### MEMORANDUM

SUBJECT: Ridgway Short Plat SP-07-39

**The following shall be conditions of preliminary approval:**

RIDGWAY SHORT PLAT
PART OF SECTION 21, T. 18 N., R. 19 E., W.M.
KITTITAS COUNTY, WASHINGTON

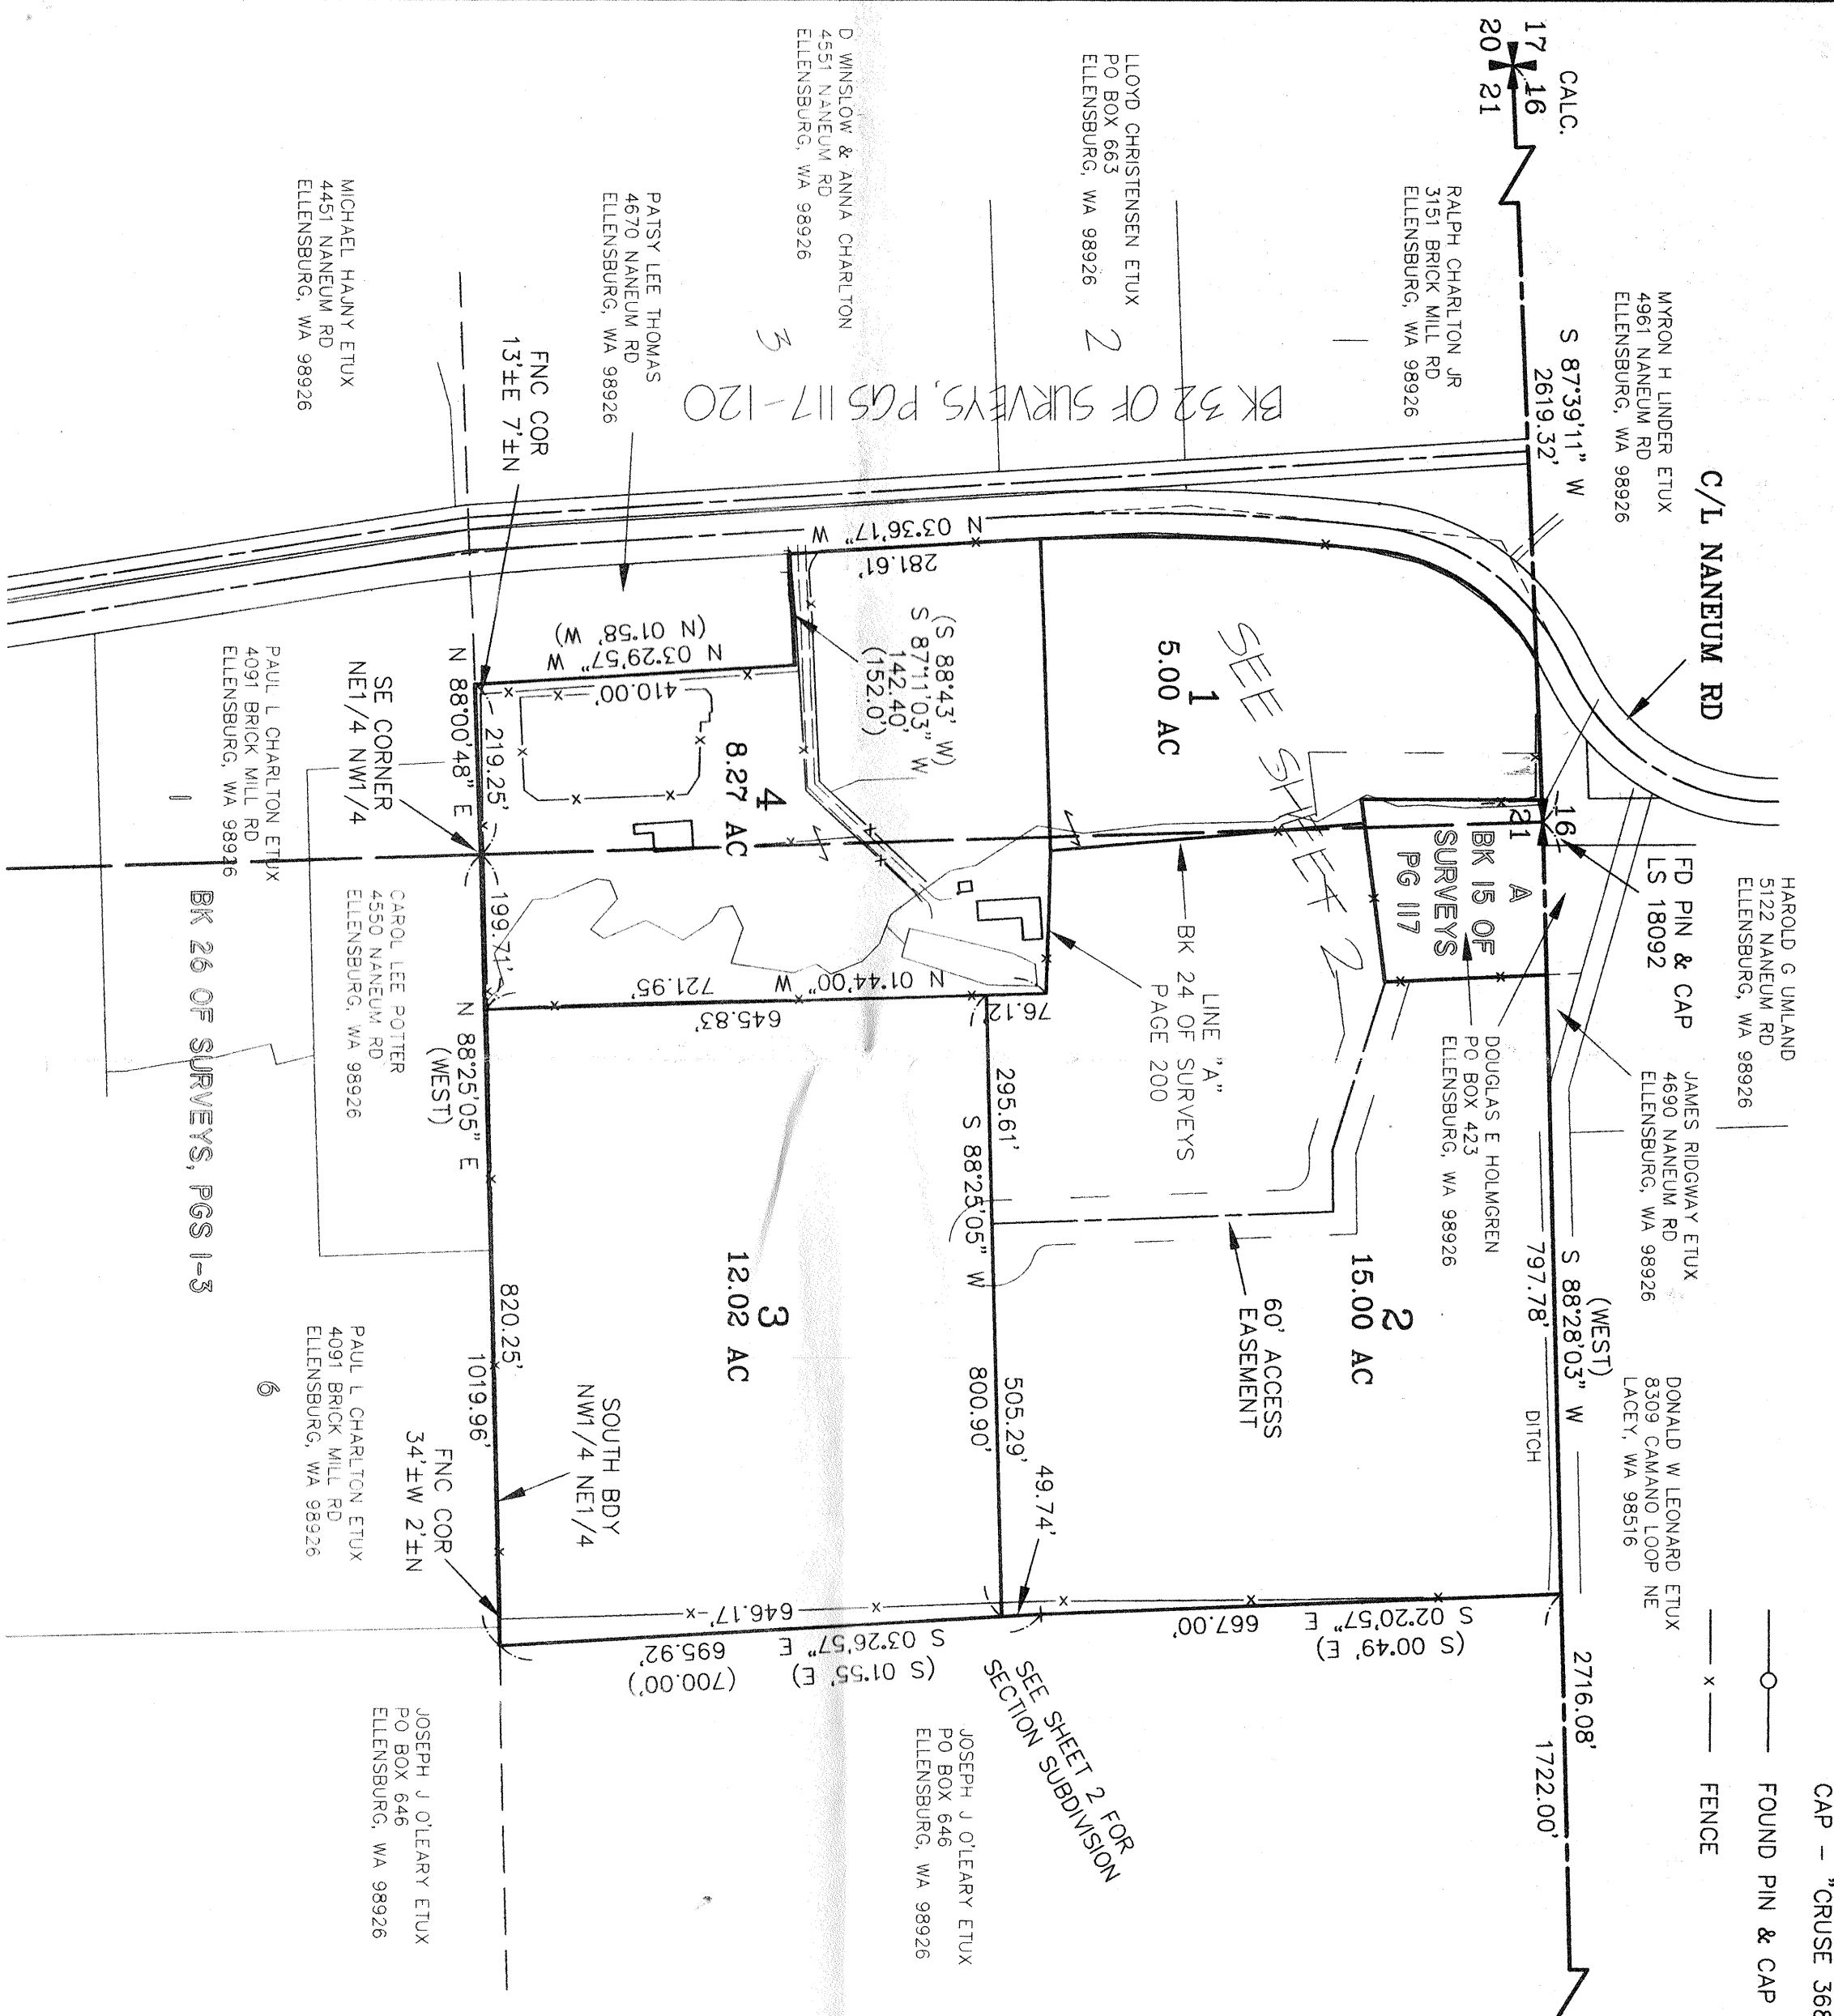
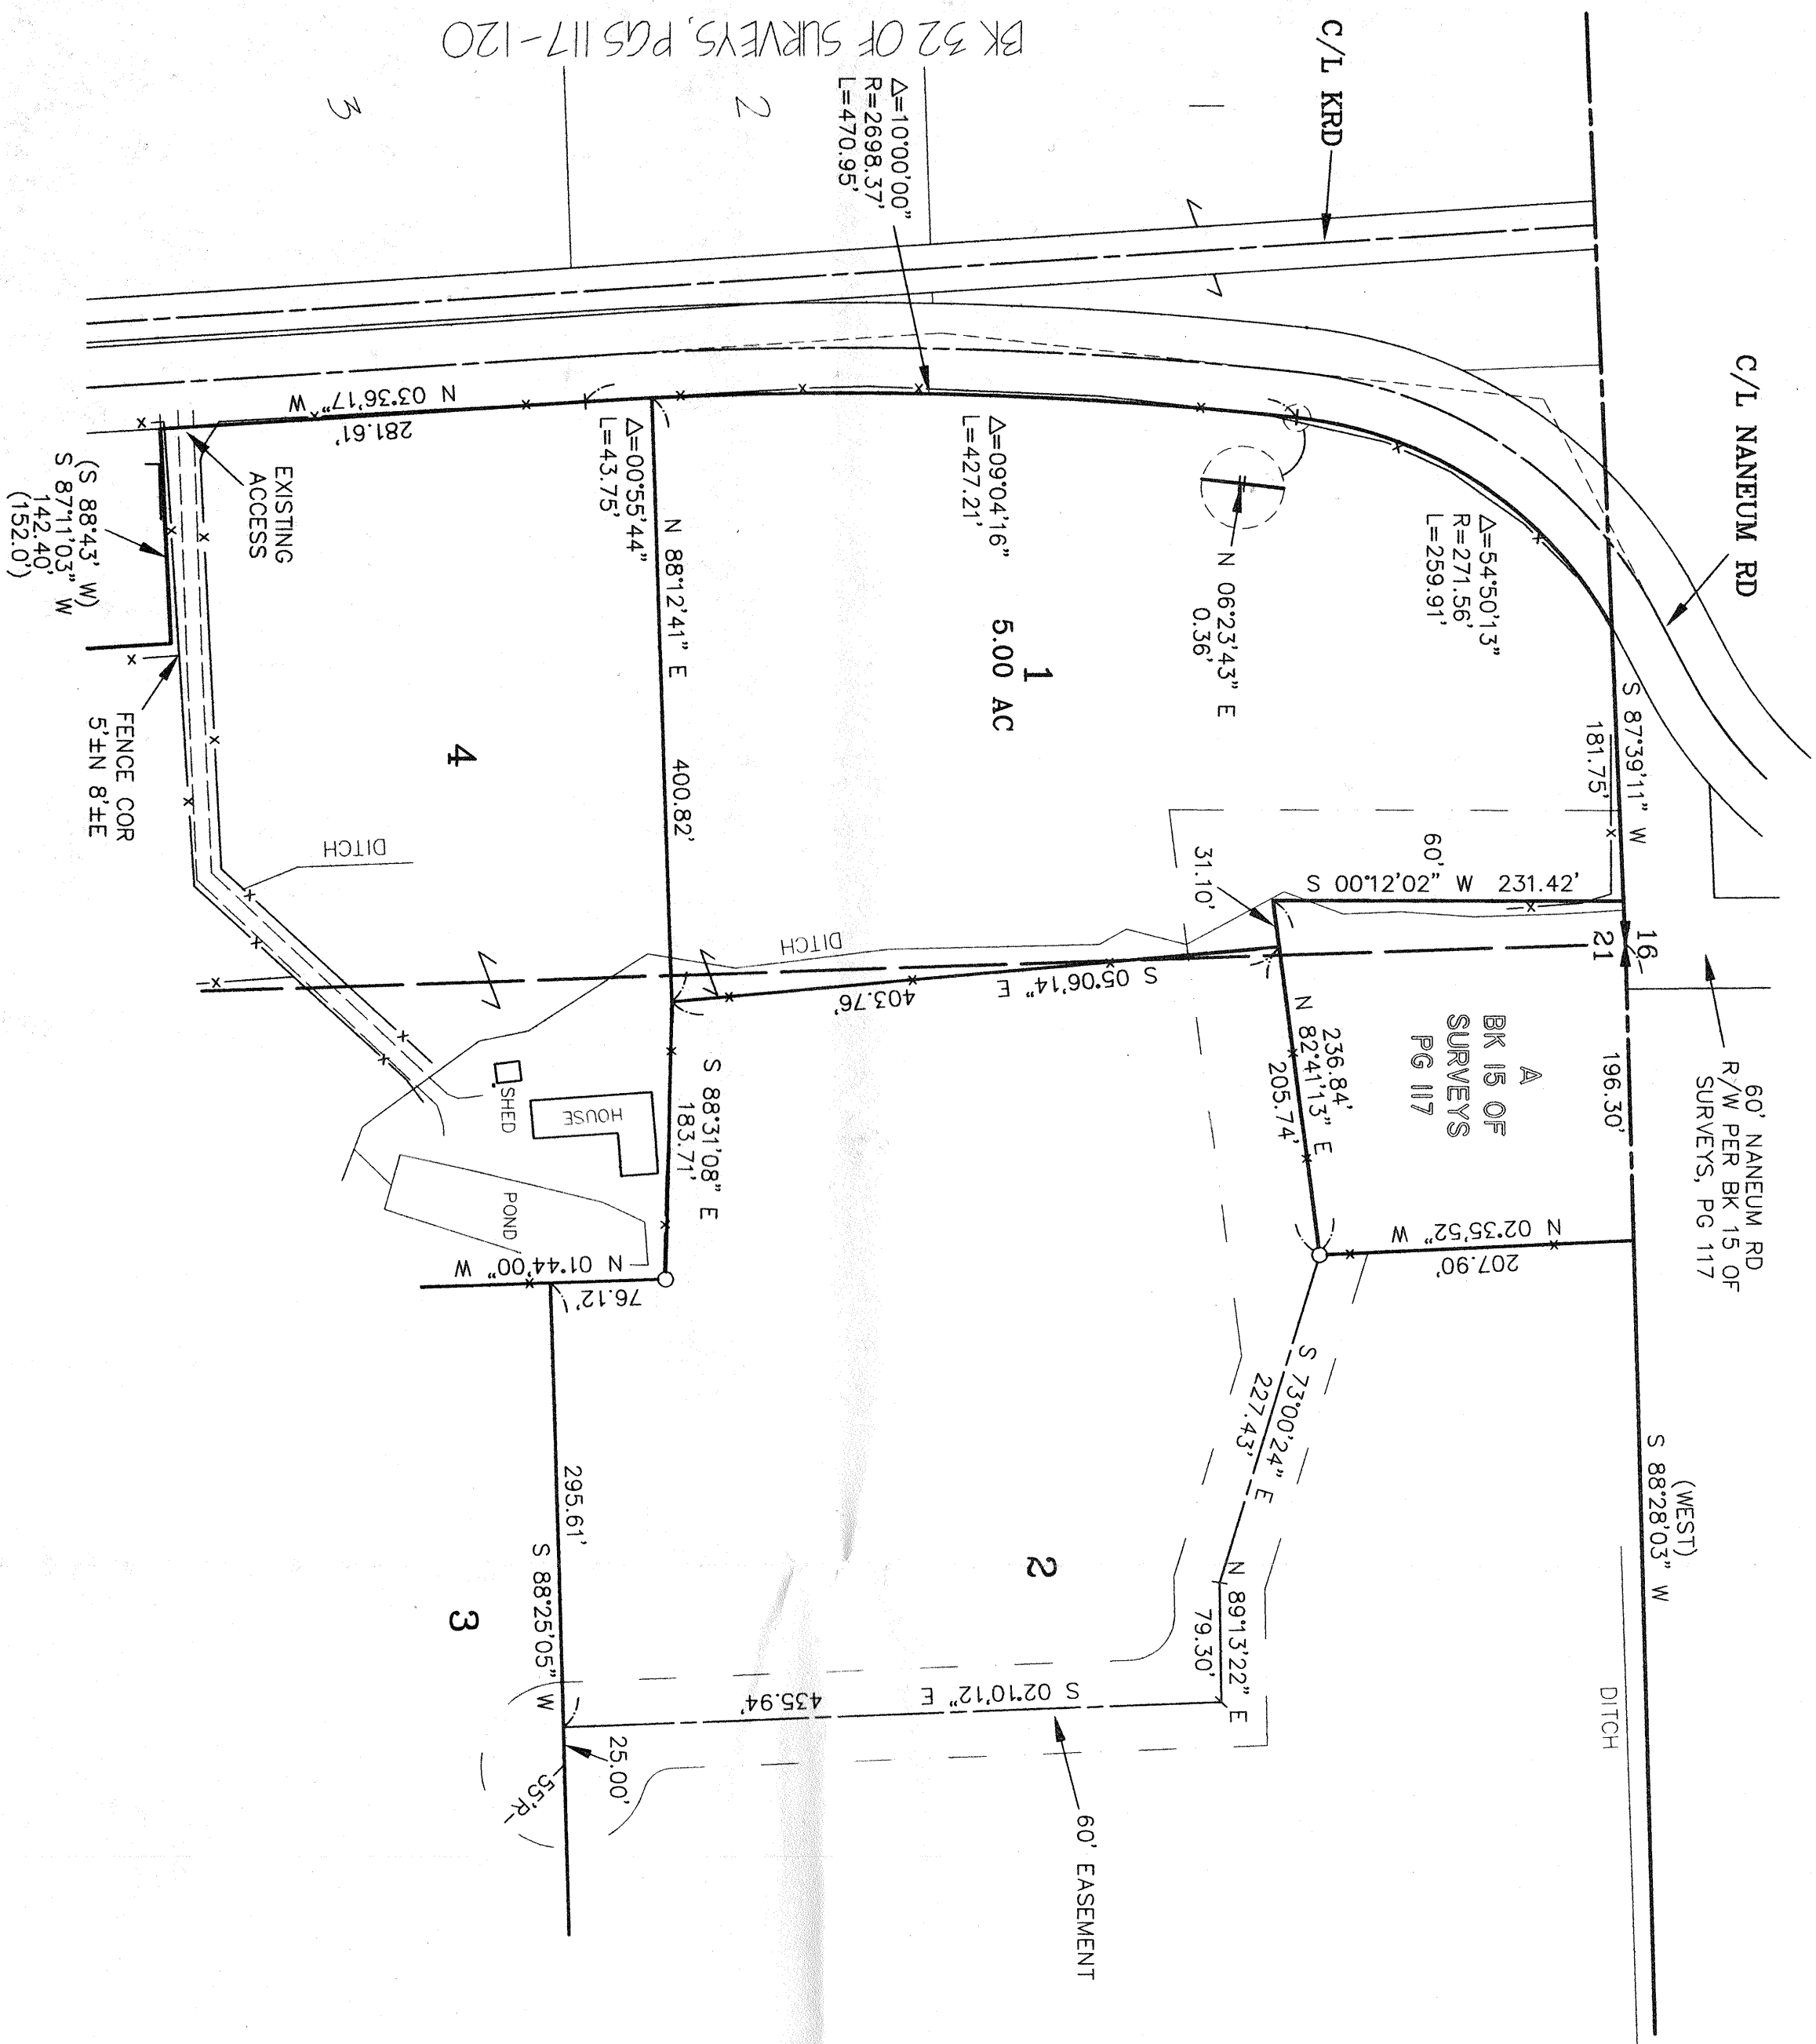
The Department of Public Works is concerned about the proposed access to the Ridgway Short Plat. We request that the applicant provide the specific location of the proposed access and roadway for review prior to preliminary approval.

The applicant should also be aware that all bridges must meet the requirements of the International Fire Code, including the 75,000 lb load rating.

RIDGWAY SHORT PLAT

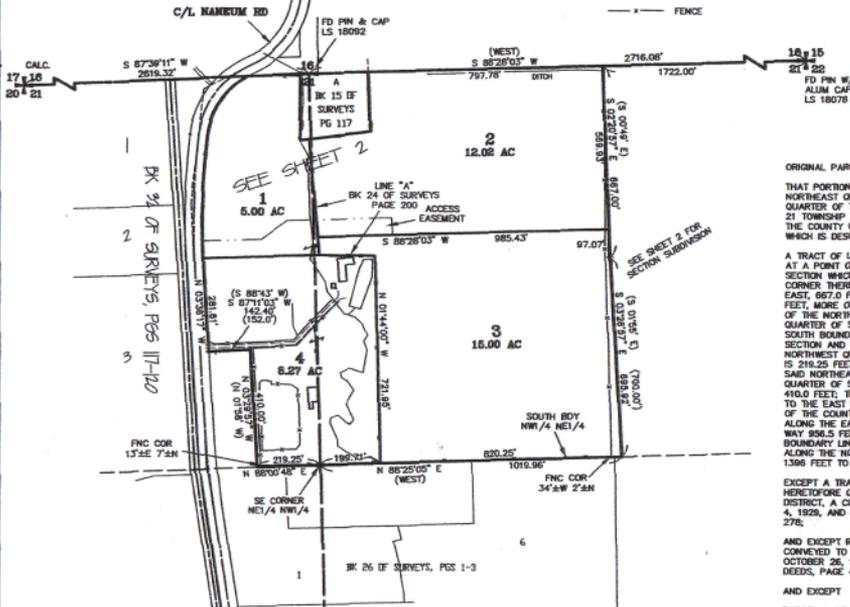
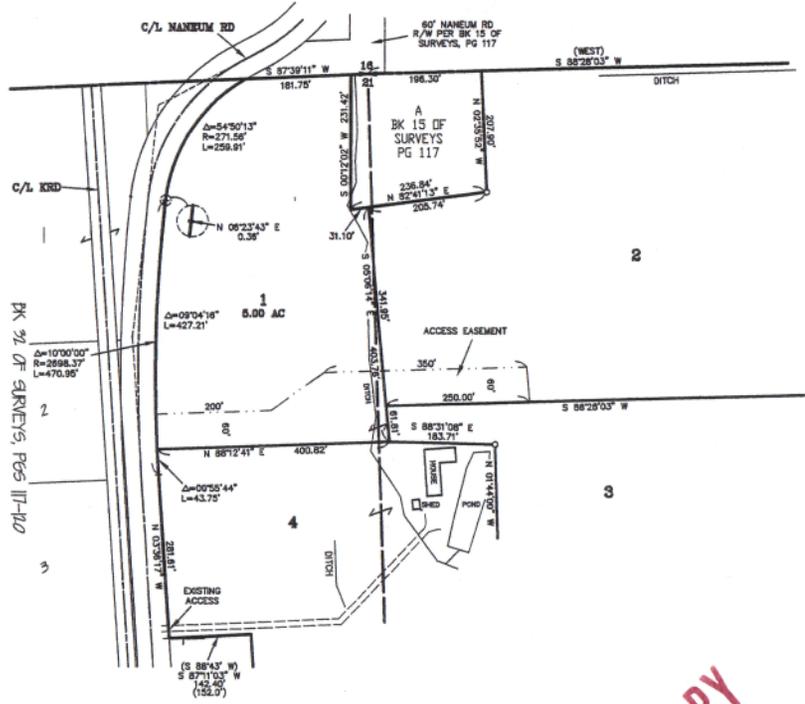
3. Turnaround: Either a hammerhead or a cul-de-sac turnaround may be constructed in the designated area on Lot 1. Cul-de-sacs and hammerheads must conform to the requirements specified by the 2006 International Fire Code. Contact the Fire Marshal regarding any additional turnaround requirements.

4. Private Road Improvements: Access shall be constructed to meet or exceed the requirements of a High-Density Private Road that serves 3-14 tax parcels. See Kittitas County Road Standards, 9/6/05 edition.

- a. Access easements shall be a minimum of 40' wide. The roadway shall have a minimum width of 20', with 1' shoulders, for a total width of 22'.
  - b. Minimum centerline radius will be 60'.

- c. Surface requirement is for a minimum gravel surface depth of 6".
  - d. Maximum grade 8% flat, 12% rolling or mountainous.
  - e. Stopping site distance, reference AASHTO.

- j. All easements shall provide for AASHTO radius at the intersection with a county road.
  - k. A paved apron shall be constructed at the intersection of the proposed private intersection and the county road.
